Ref: M/94/17/PL
72 Ancton Way

Our Comment Ref: OWPC 15796

Our objections are as follows:

Proposed Site Plan

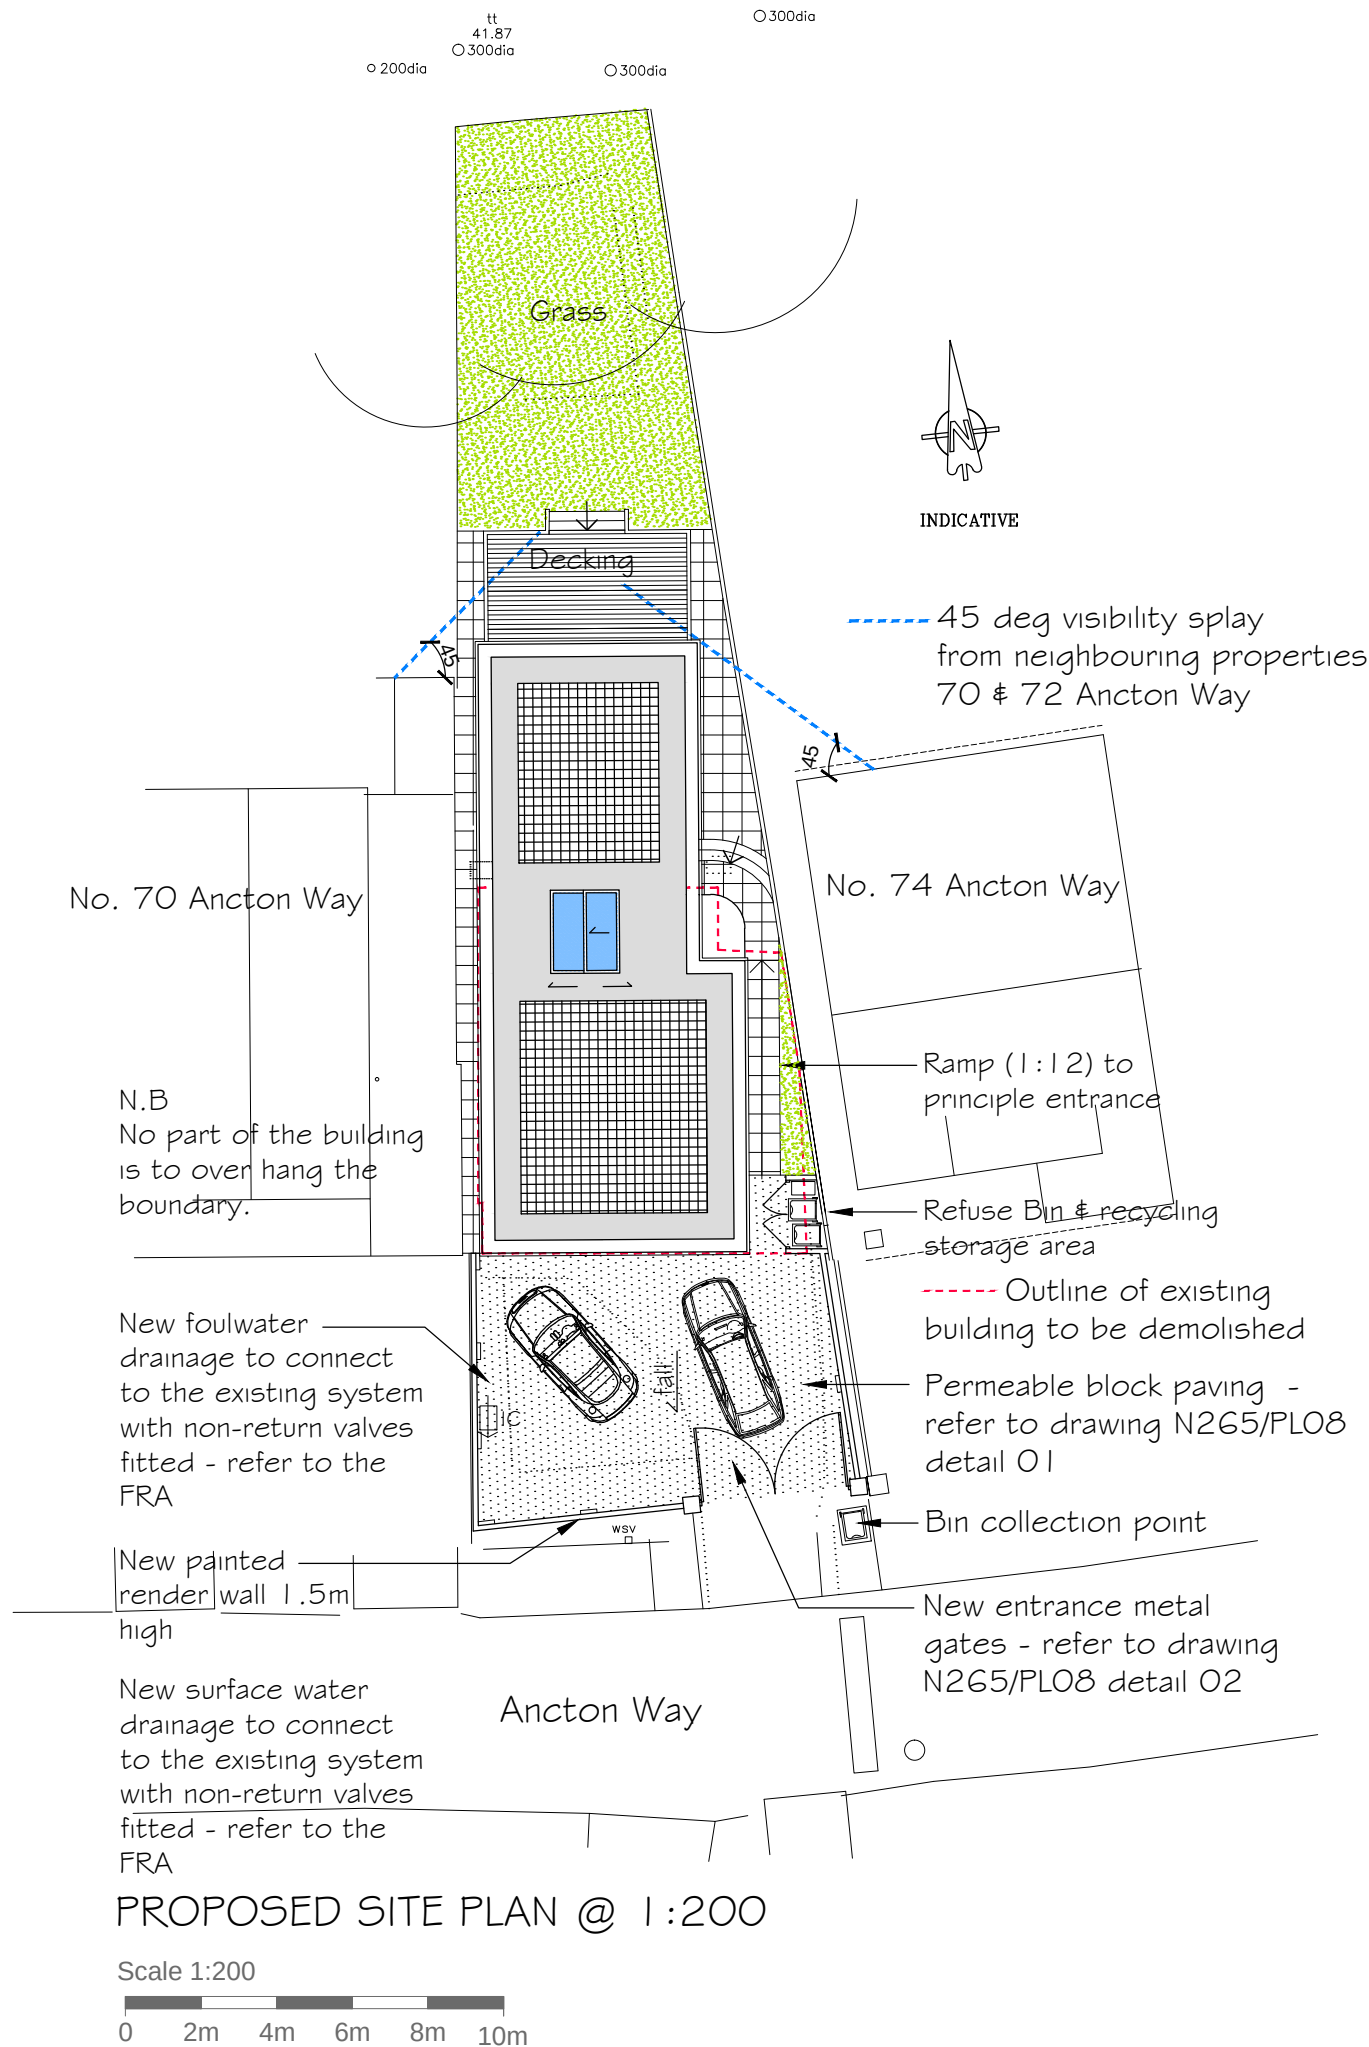
The proposed development is overbearing and out of scale relating to the plot it has been designed for. In terms of its appearance/scale/size it does not integrate with the existing properties in the close vicinity. Sample photos given by the applicant are in no way relevant or close to Ancton Way, they are all in large detached plots facing the sea and not other properties.

It is our understanding that a new build should be at least 1m from the adjacent building. At present the gap is 400mm and as we understand from the planning application this will be the proposed exterior wall of the new building so does not equal the 1m distance. If planning is granted we can see no possibility of this wall being built, there would be no space for scaffolding

In conclusion to our objections we feel that this application is unacceptable as it is a high density/over development of site, out of character of properties that are next to and opposite, loss of garden land and the open aspect of neighbour.

Proposed Floor Plans

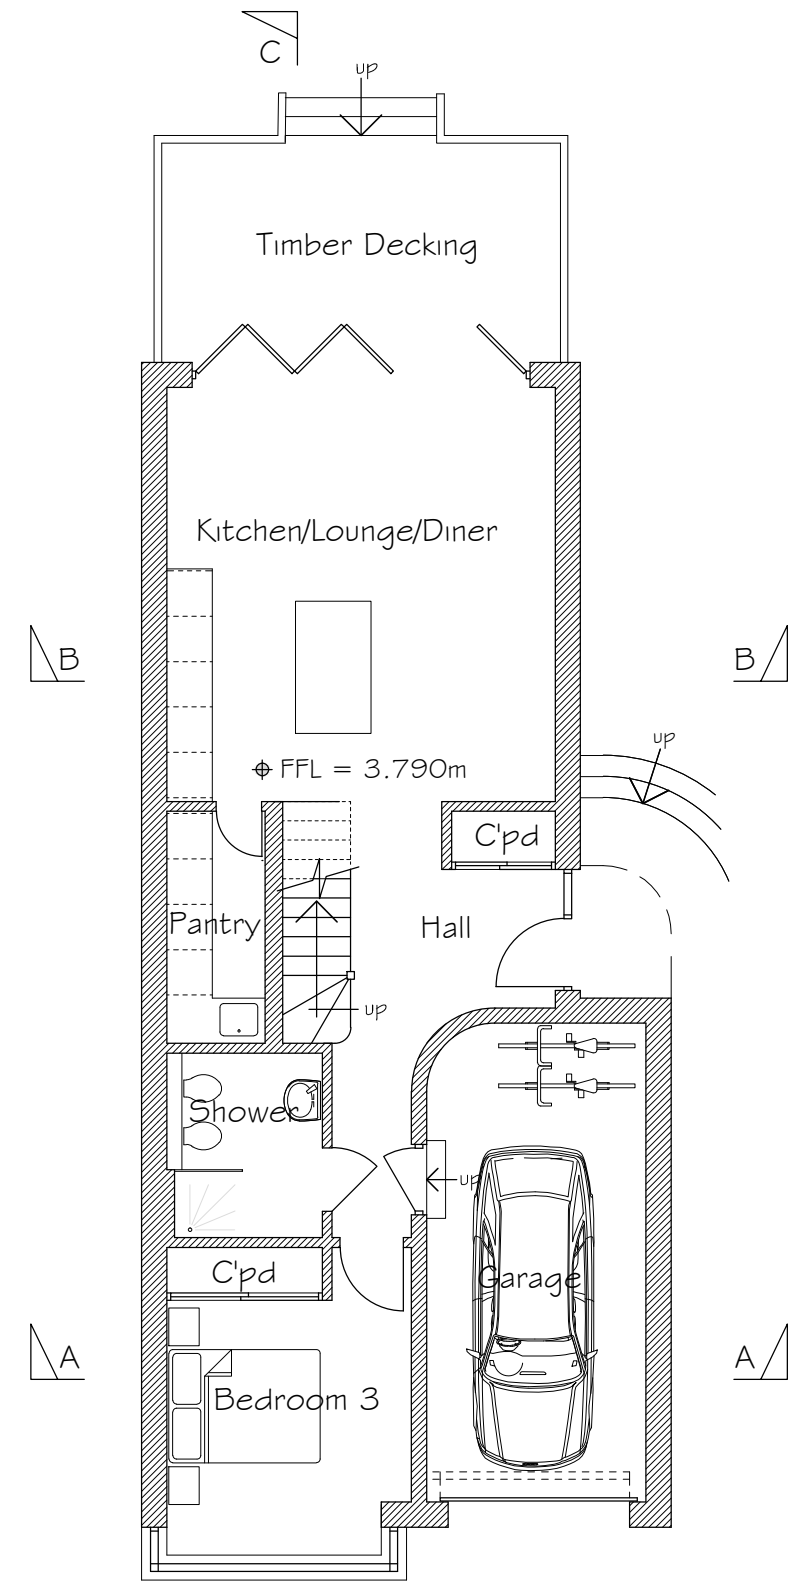
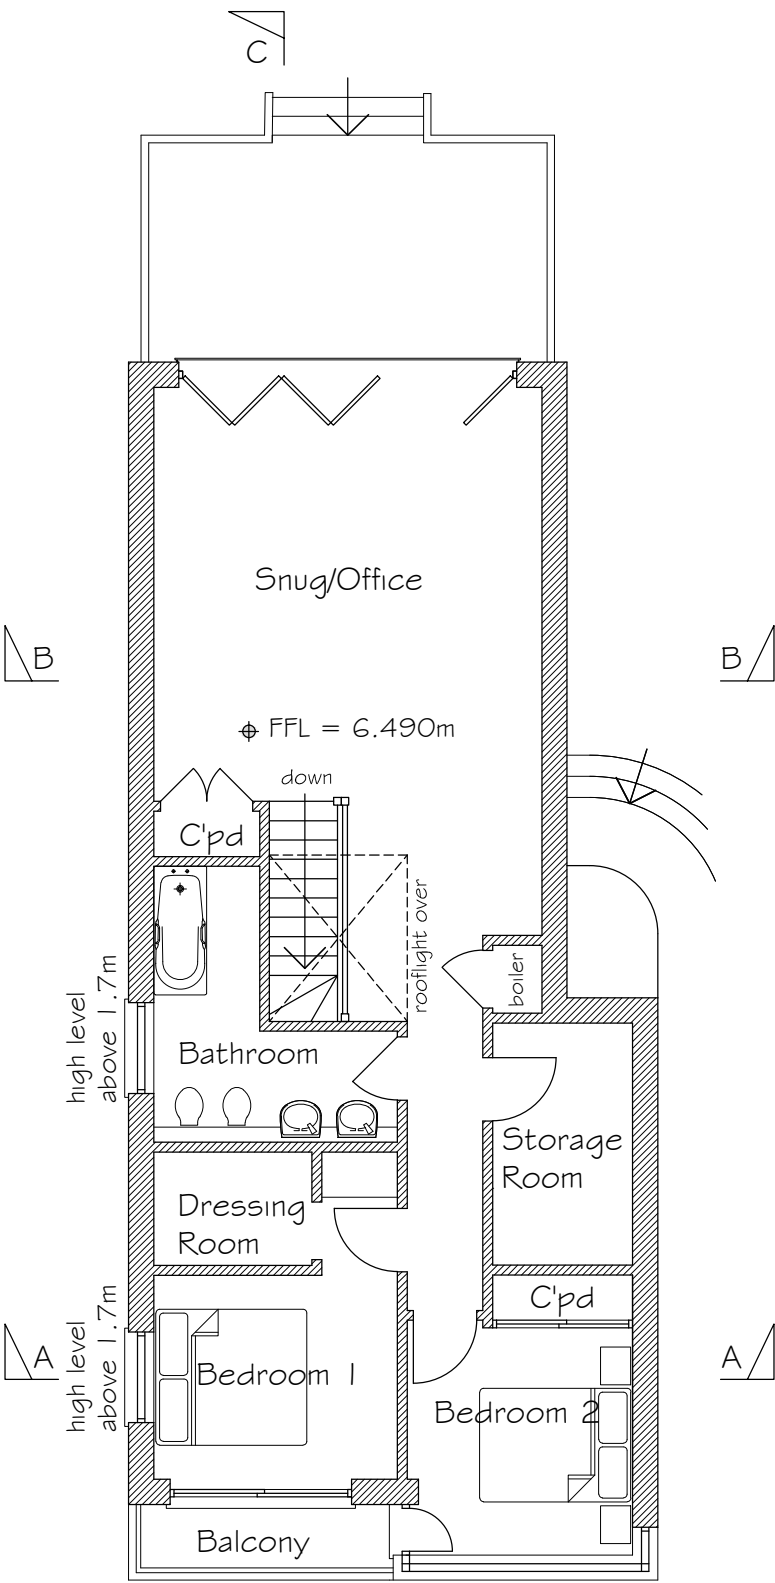
There are also large concerns that the balcony on the first floor will overlook us at the front and the balcony and patio doors at the rear first floor will overlook the whole of our patio and garden with no private areas at all. The very close side wall is to have 2 windows built into at present there are zero windows. It states that they are to be powdered but if permission is granted we think frosted would be more appropriate.

PROPOSED SOUTH ELEVATION
SHOWING FRONT BOUNDARY
AND GATES @ 1:100

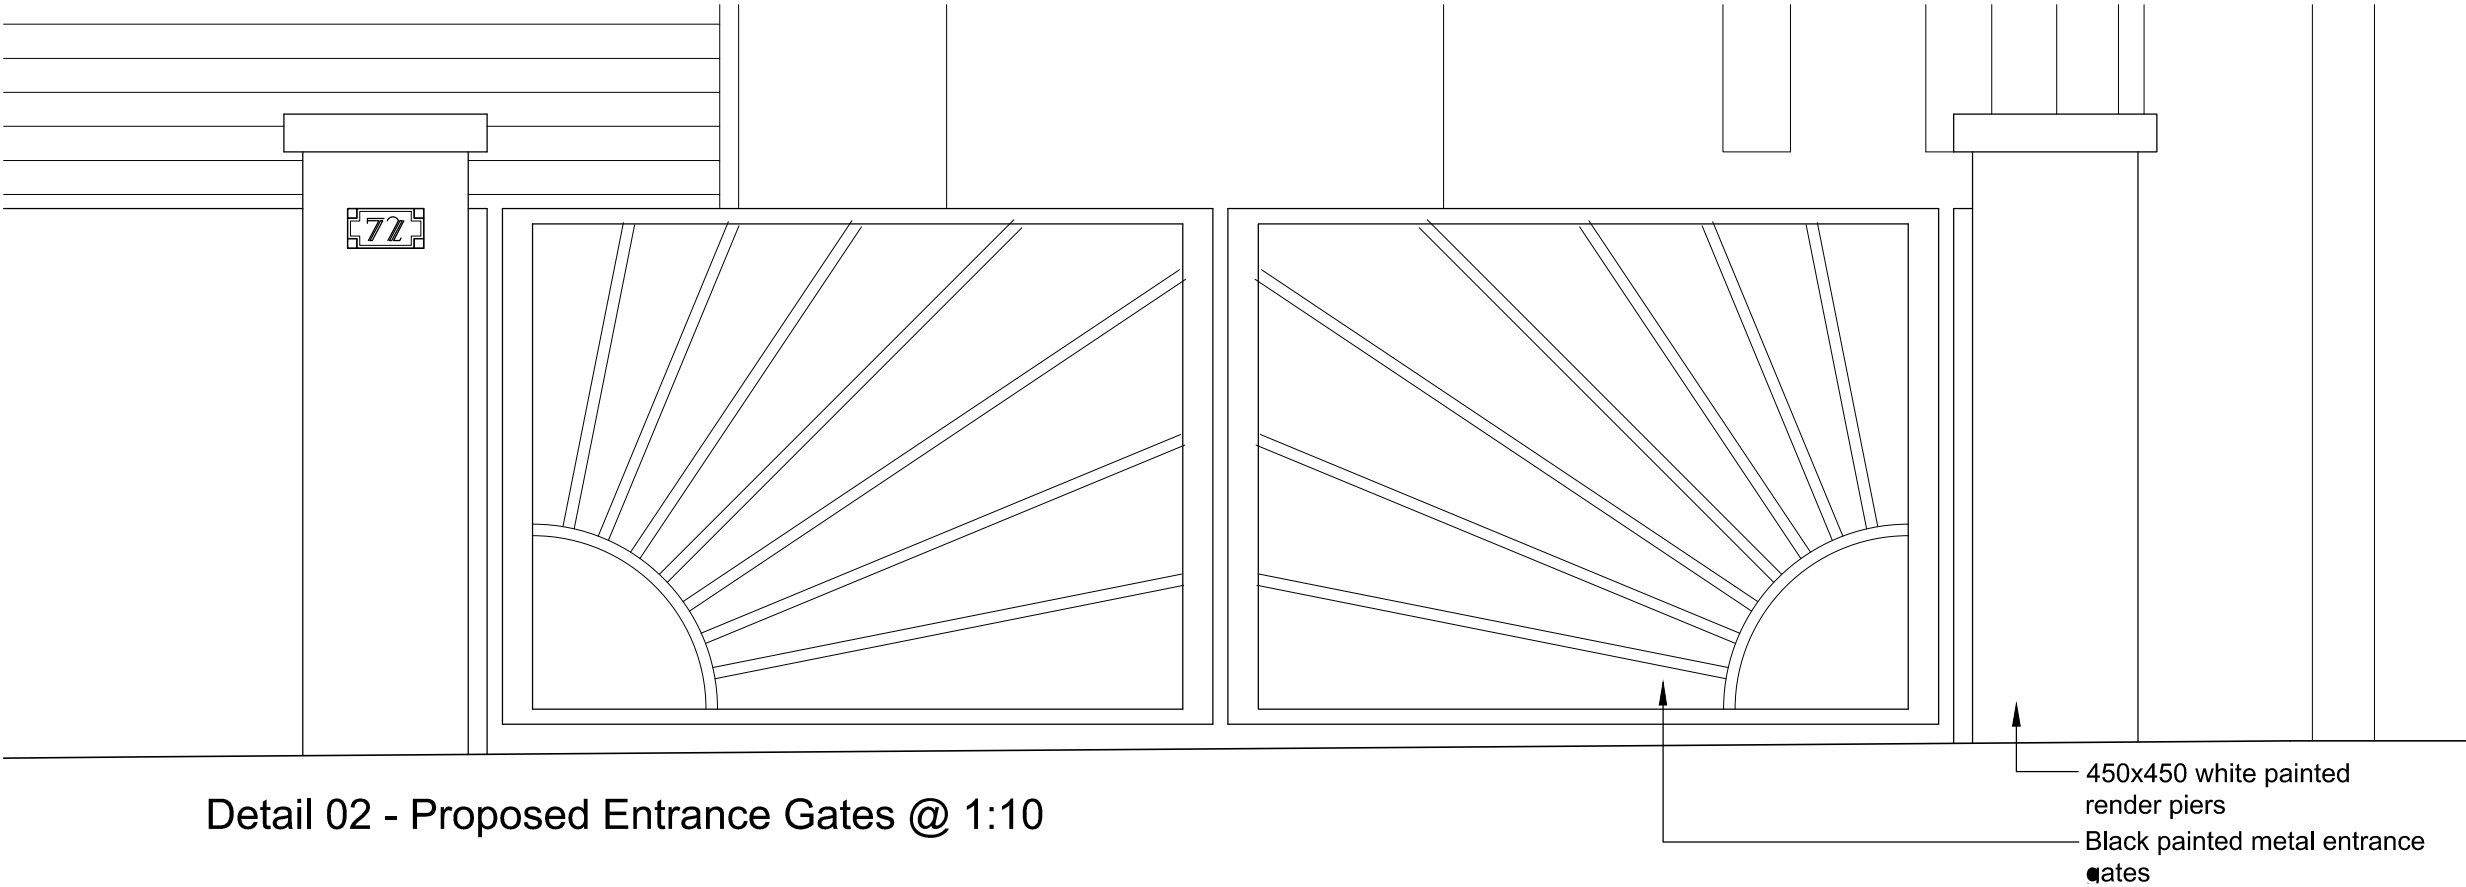
To the front of the building it is proposed to have a 1.5m wall, the vision will be restricted to vehicles exiting the property and to vehicles passing by.
